From: Tom Wessely <[REDACTED]>
Sent: 02 September 2021 16:36
To: Simon Davis
Cc: David West; Andy Mckeown-Mundy; Ian Johnson
Subject: Re: Condition 5 ref. Y/97/21/DOC
Attachments: Plots 1.2.3.20.21 _ Elevations.zip

North-West Elevation

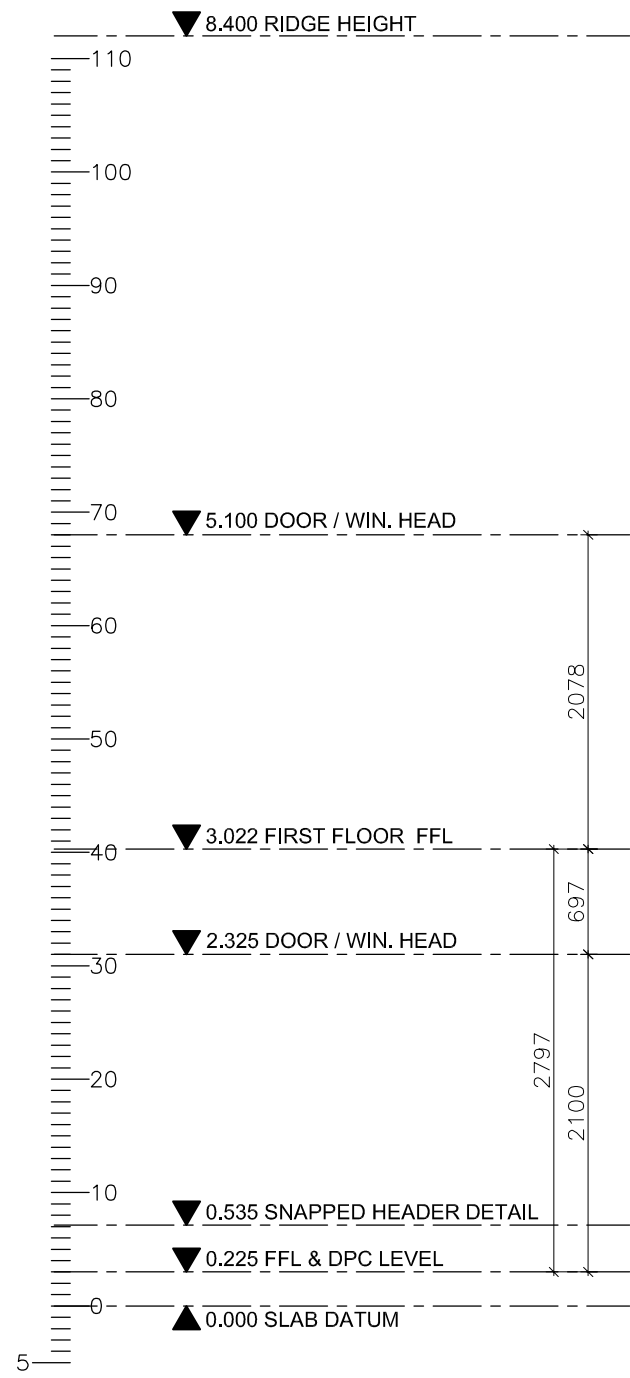
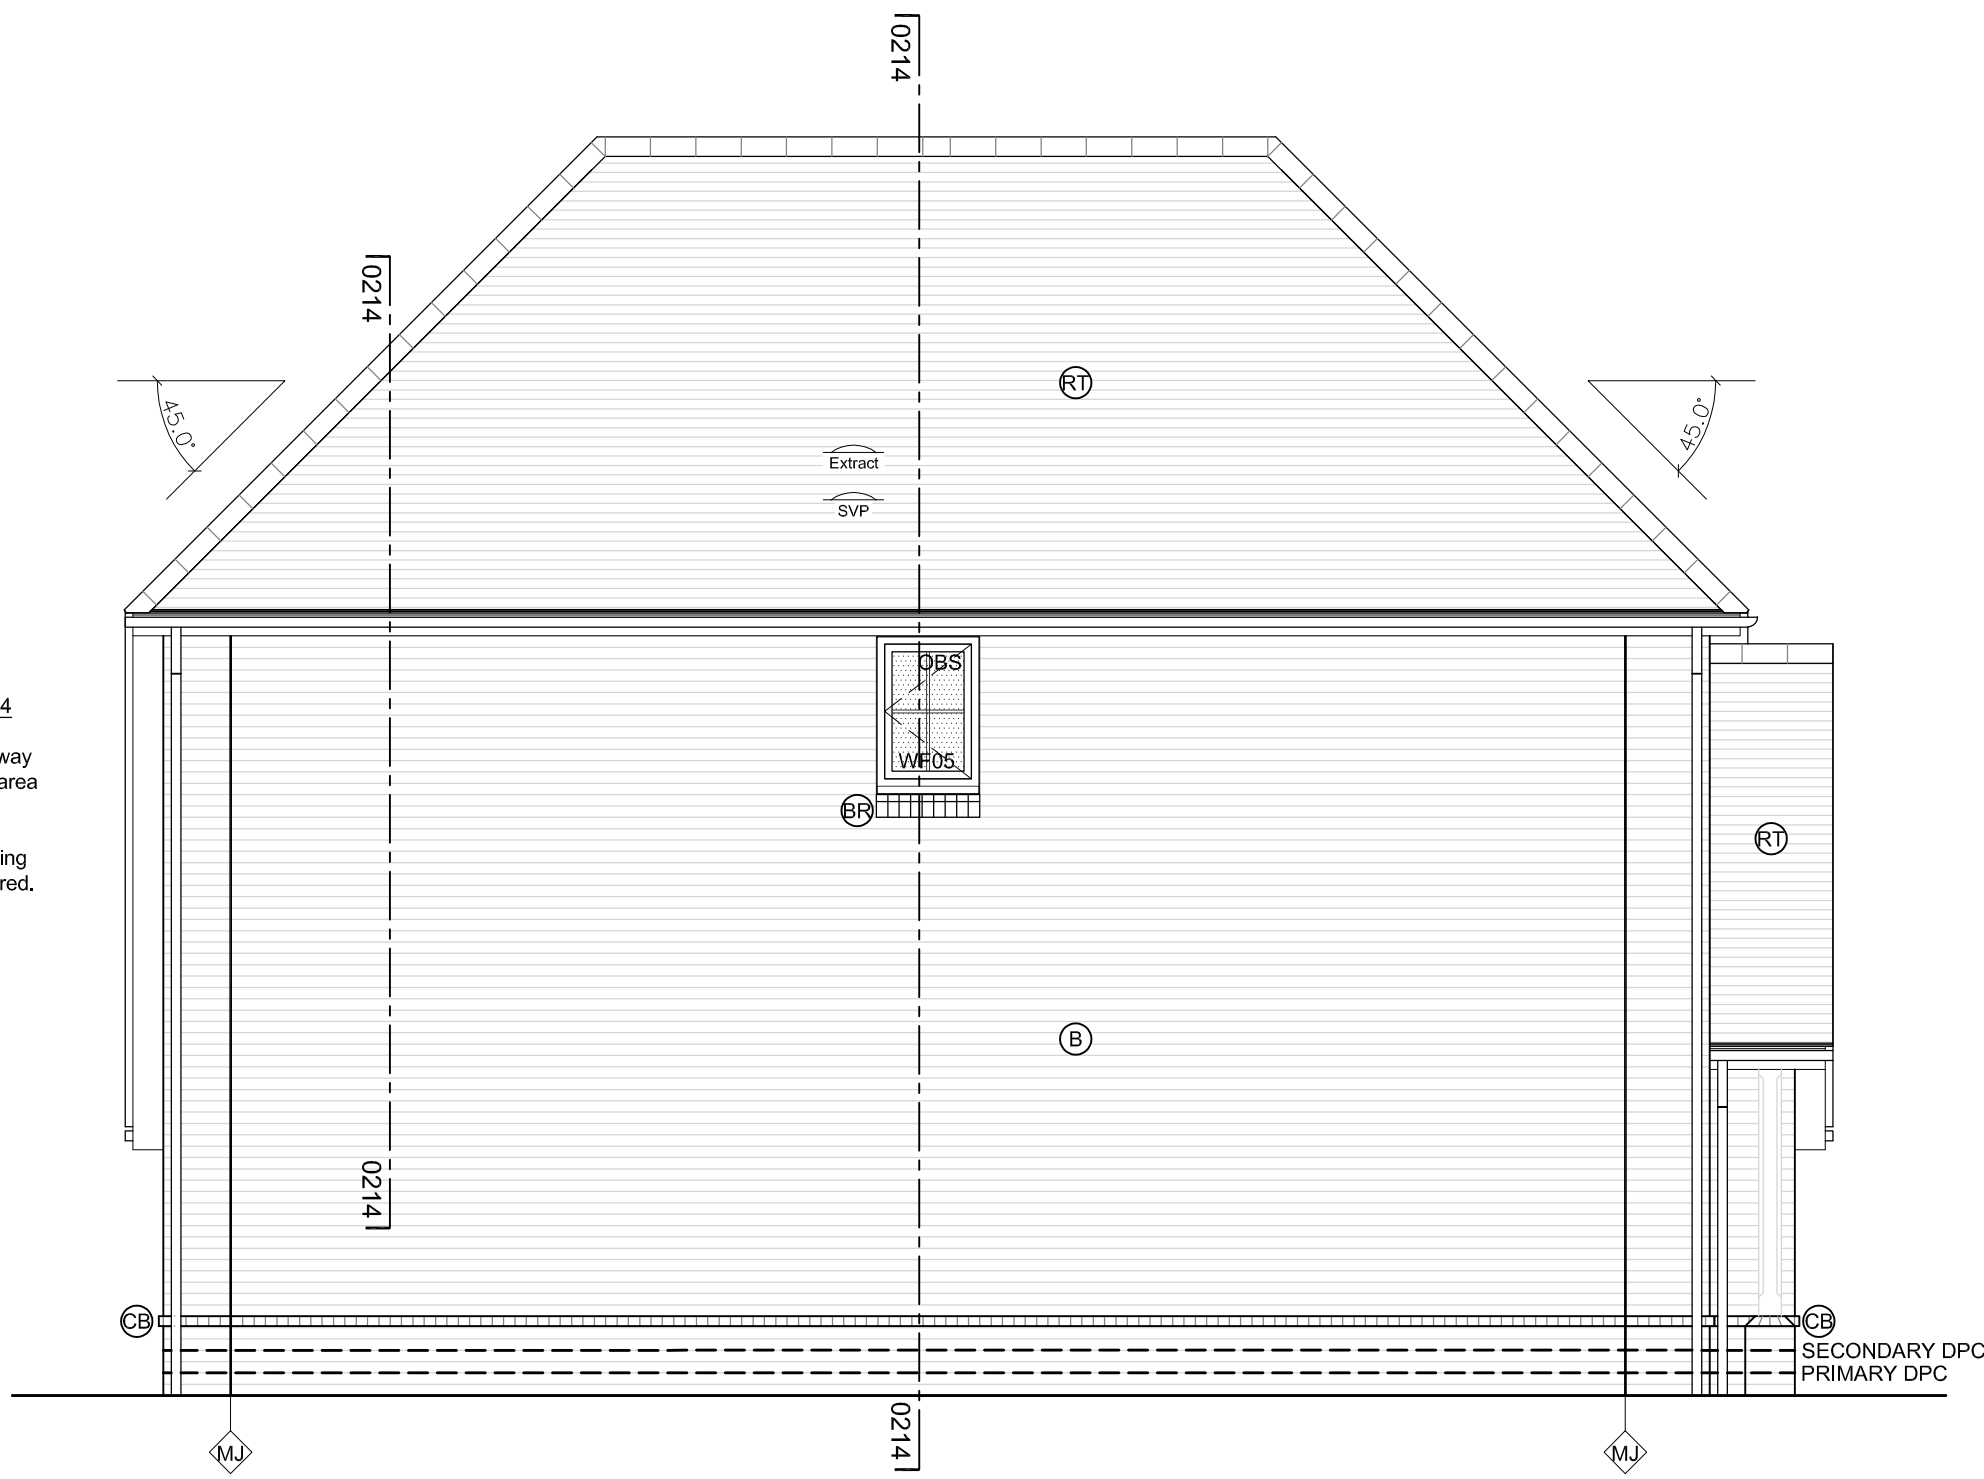
Secondly, we have no plans referring specifically to plots 1, 2, 3 and 19-21 which are named in the condition. Can you advise the position in respect of these? Are they covered by the above plans? If they are then its not clear from the drawings.

Please see enclosed elevations for plots 1, 2, 3, 20 and 21. I am not in a position to provide you with the drawing for plot 19, however I can confirm that this plot will also have white painted timber windows.
